WELWYN HATFIELD COUNCIL – DEVELOPMENT CONTROL
DELEGATED REPORT

APPLICATION No:	S6/2007/1242/FP
------------------------	------------------------

The application seeks full planning permission to extend the existing dwelling and demolish the existing attached garage and rear lean-to extension as part of the project.

SIDE ELEVATION (SOUTH)

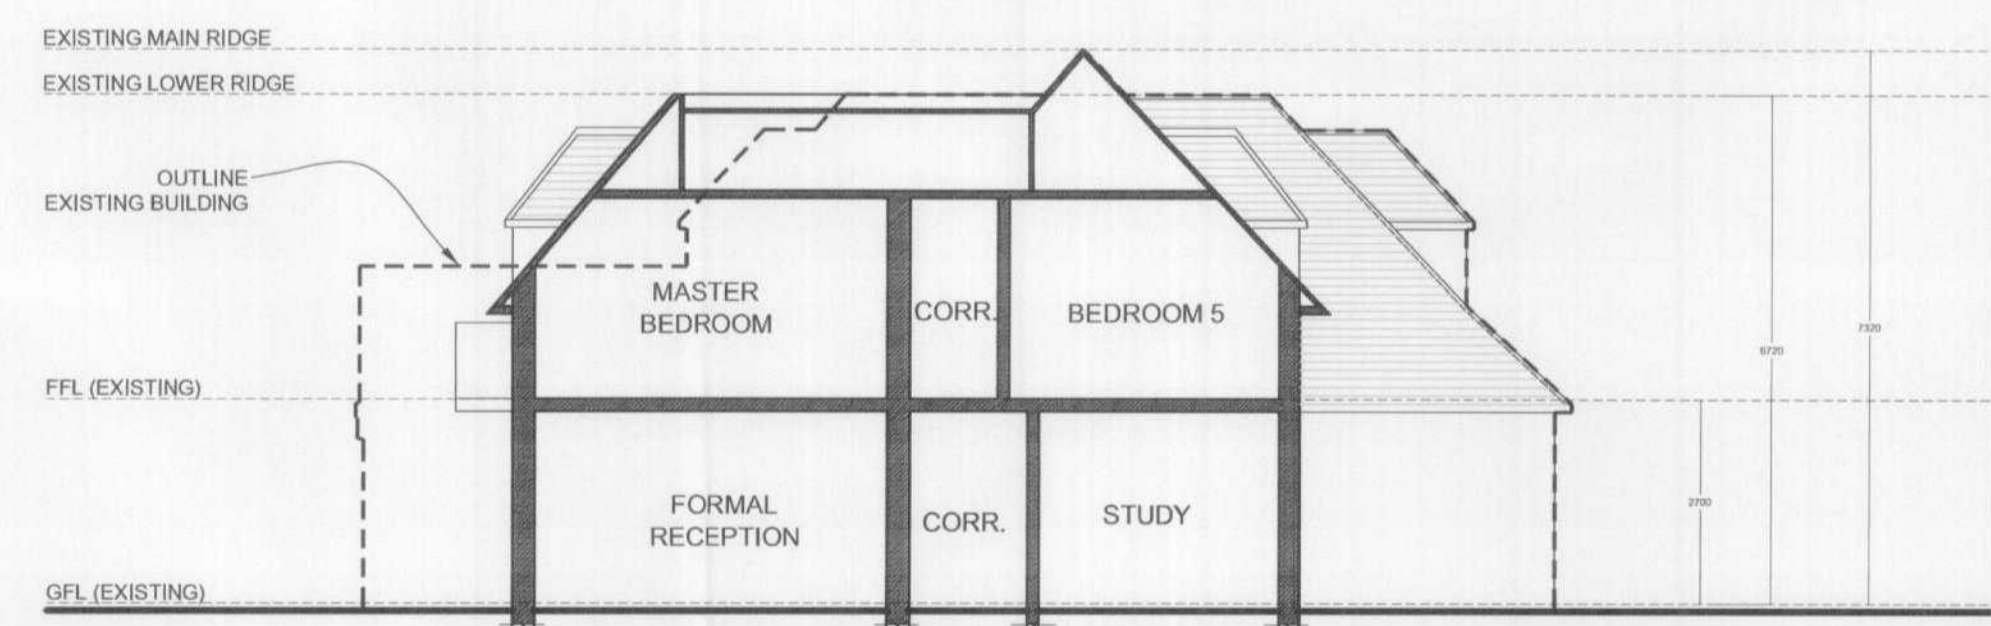
There would be one window at first floor level in this elevation facing 51 Kentish Lane, however this serves an ensuite and as such could be conditioned to contain obscured glazing and be non-opening below 1800mm to minimise the potential for overlooking. In addition, the proposed balconies to the rear elevation are not considered to create unacceptable overlooking due to the oblique angles and separation distances between properties.

- 4) C.7.9 – Fixed and Obscured Glazing to first floor side dormer bathroom window (south) elevation.
- 5) The garage building identified by a dotted line on drawing ELP_210 shall be demolished before construction works commence on site.
Reason – To preserve the openness of the Green Belt and comply with Policies RA1 and RA3 of the Welwyn Hatfield District Plan 2005 and Policy 5 of the Hertfordshire Structure Plan Review 1991-2011.
